Addendum No. 1

RE: Contract ID: C201955
WBS# 39418
Washington County
NC-45/99 From NC-32 to Hyde County Line

December 18, 2007 Letting

TYPICAL SECTION

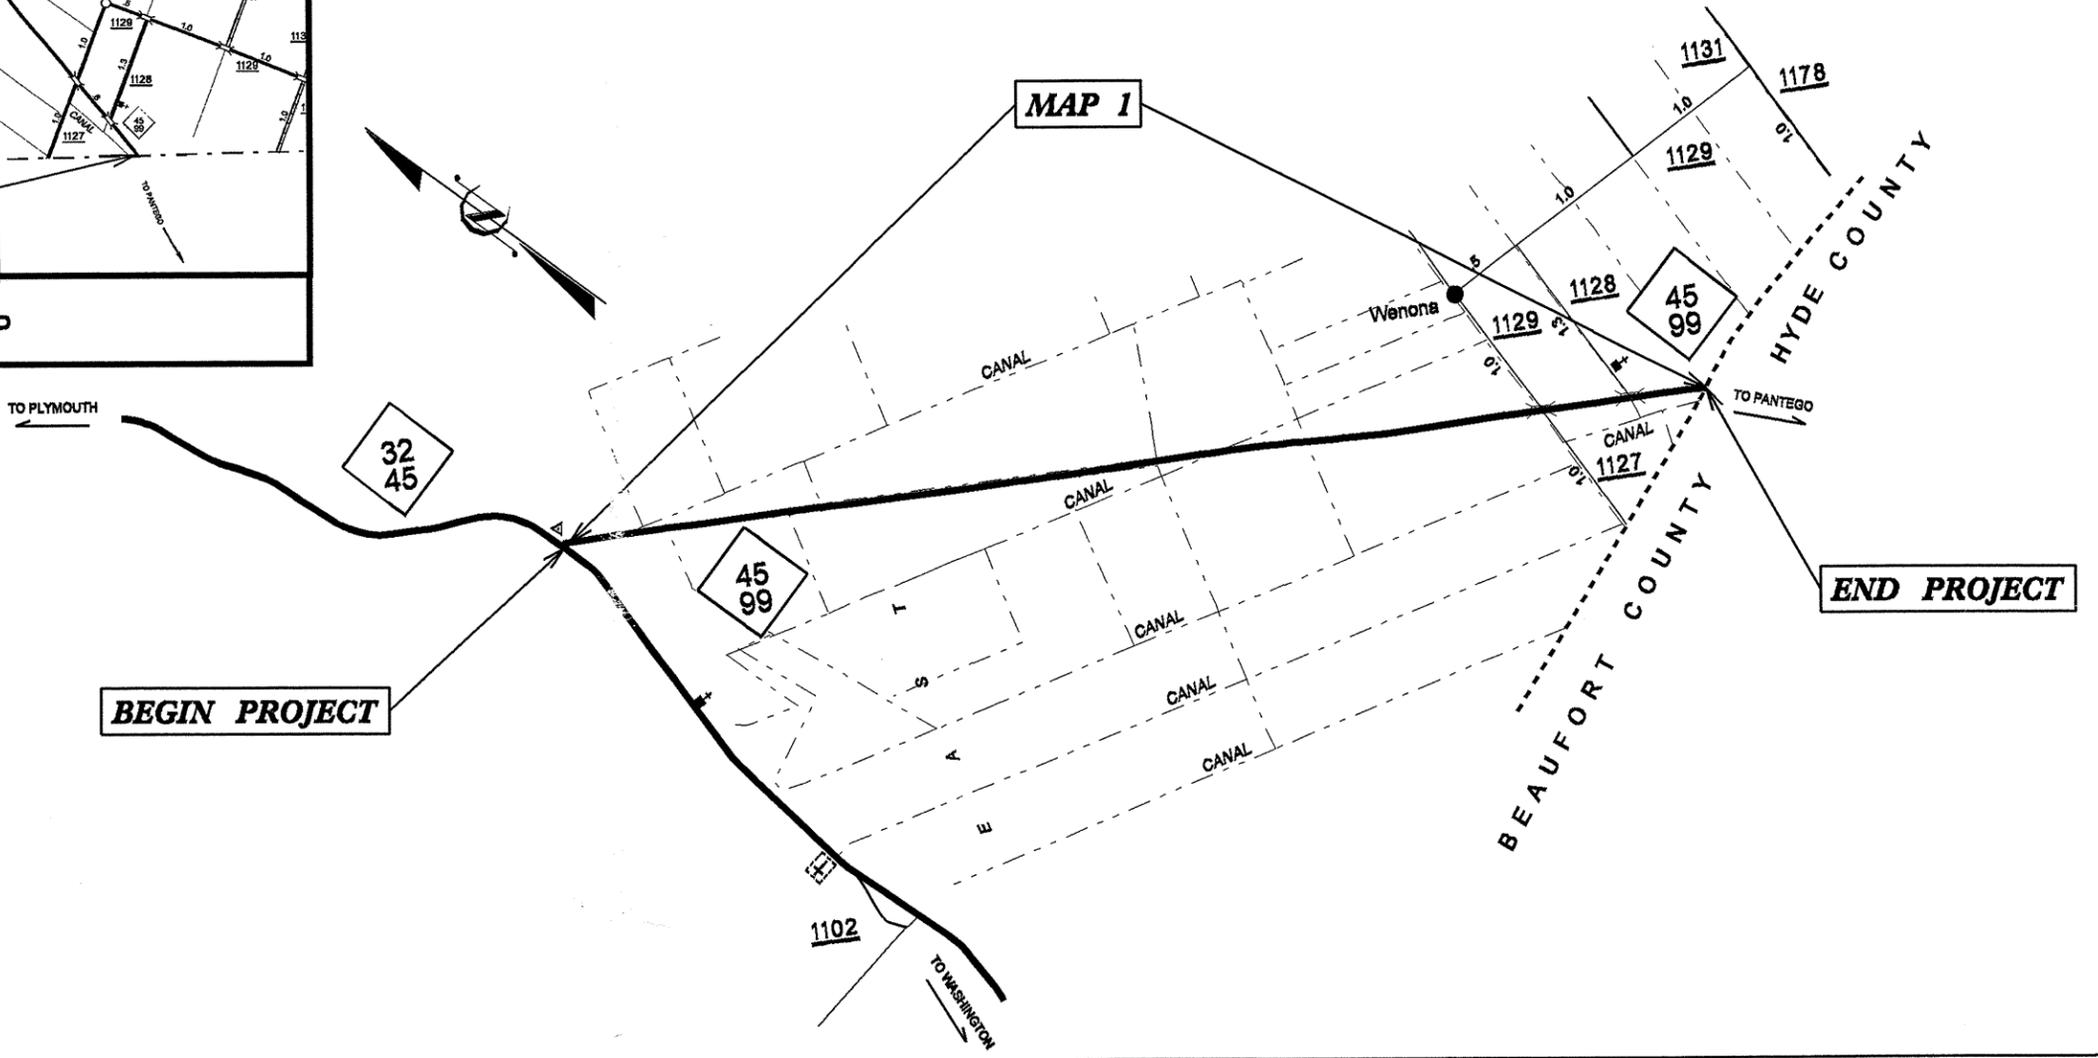
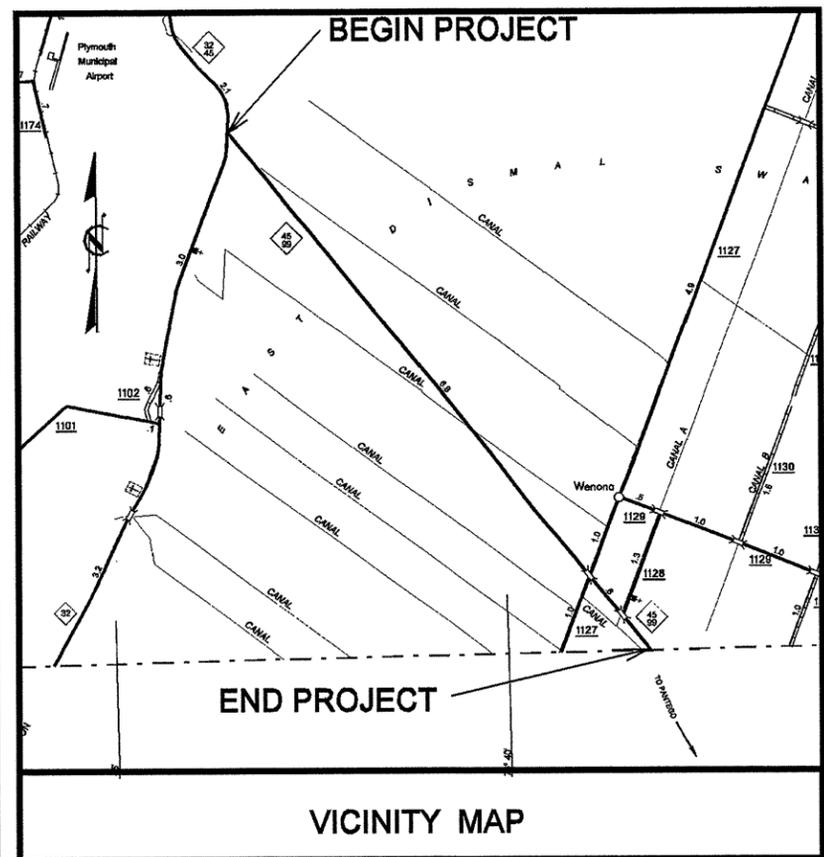
Sheet No. 2 has been revised to change the Leveling Course Limits on the Typical Section.
Please void Sheet No. 2 in your sketch maps and staple the revised Sheet No. 2 thereto.
